City of Albuquerque

**Re: Grading and Drainage Certification – McDonald's/Gas Station
(J-14/D109) (SE corner Broadway & Lomas)
Engineer's Stamp dated 11/2/1999
Engineering Certification dated 12/22/2000**

Based upon the information provided in your submittal dated December 22, 2000, the Engineering Certification for Certificate of Occupancy for the project referred to above is *disapproved*.

DRAWN BY: DATE: OCTOBER 26, 1999 SHEET 2 OF 6

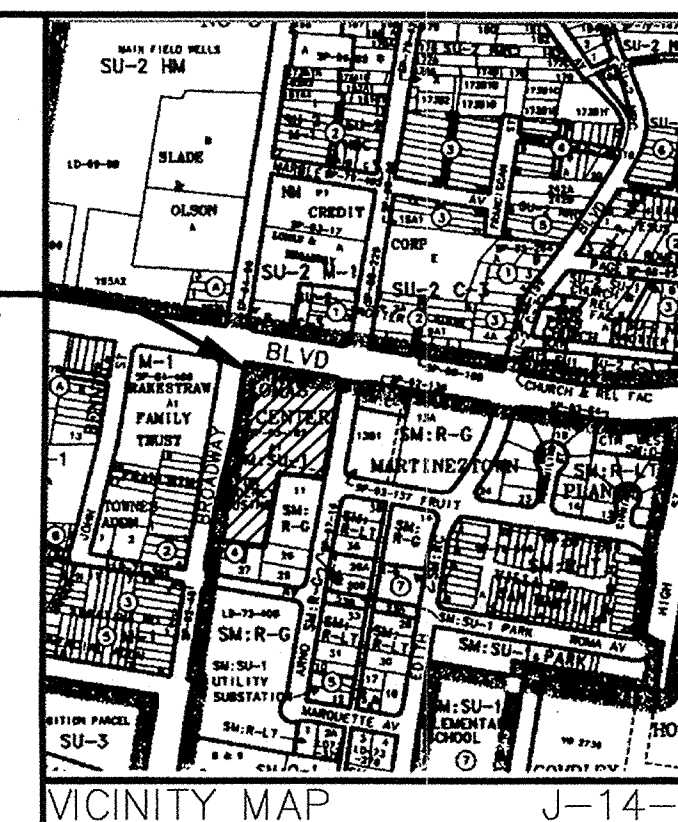
Prior to issuing a permanent Certificate of Occupancy, the revised storm inlet on Lomas Blvd needs to be included on the Engineers Certification which will require the City's storm drainage mainenenance inspector's signature on the submittal prior to approval.

Keep in mind the engineers certification should state the Certificate of Occupany does not include the future pad site.
